October 23, 2014

**Re: Beehive Homes, 13440 Wenonah Ave SE
Master Grading and Drainage Plan dated 10-8-14
Phase I, Phase II, and Phase I and II Details Grading and Drainage Plans
dated 10-8-13
(L23/D022)**

Your submittal was received October 8, 2014. The above referenced plans are not approved for Building Permit until the following comments are addressed:

ENGINEER'S SEAL	BEEHIVE HOMES	DRAWN BY WCUJ
DAVID SOULE NEW MEXICO REGISTERED PROFESSIONAL ENGINEER 14522	GRADING AND DRAINAGE PLAN	DATE 10-02-13
	Rio Grande Engineering 1606 CENTRAL AVENUE SUITE 201 ALBUQUERQUE, NM 87106 (505) 872-0999	21227-AYOUT-7-13-12
		SHEET # 1
		JOB # 21227

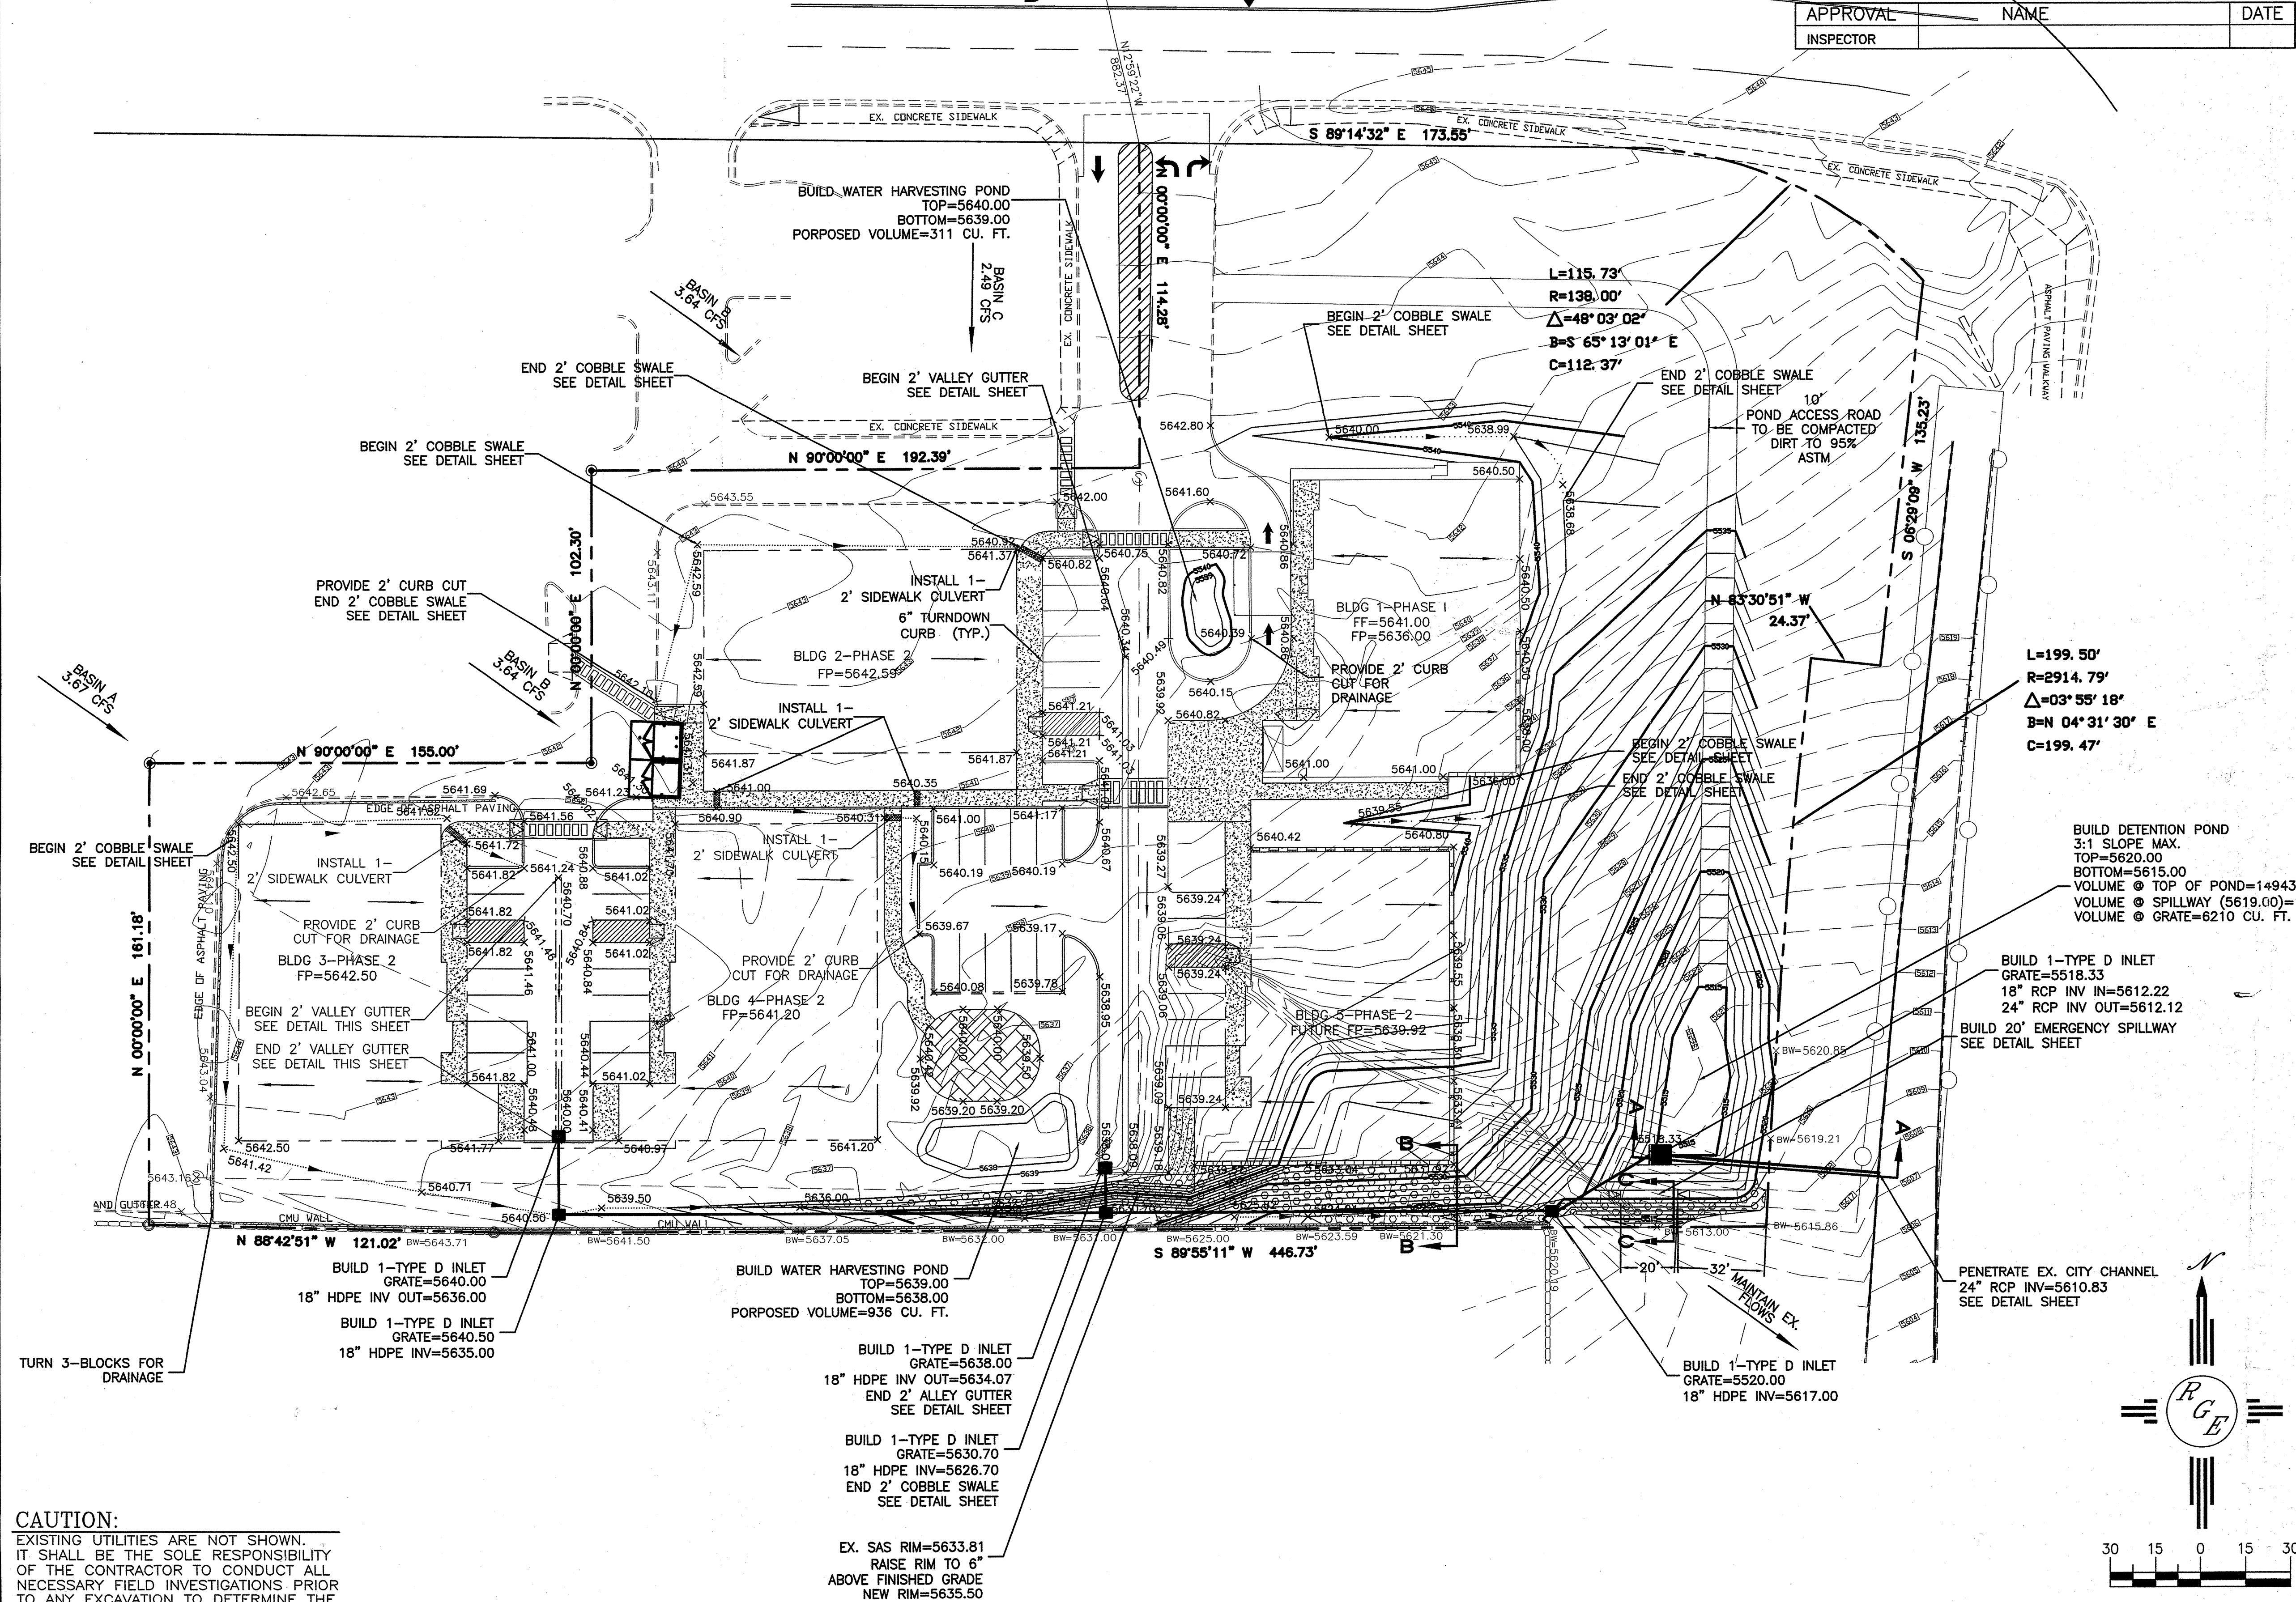
4. My previous letter commented that "the overflow spillway on the south side is being supported only by a chain link fence. The owner has stated he owns the property to the south. From the south side of the spillway, provide grading with less than 3:1 slope onto the property to the south." This has not been corrected on the plans.
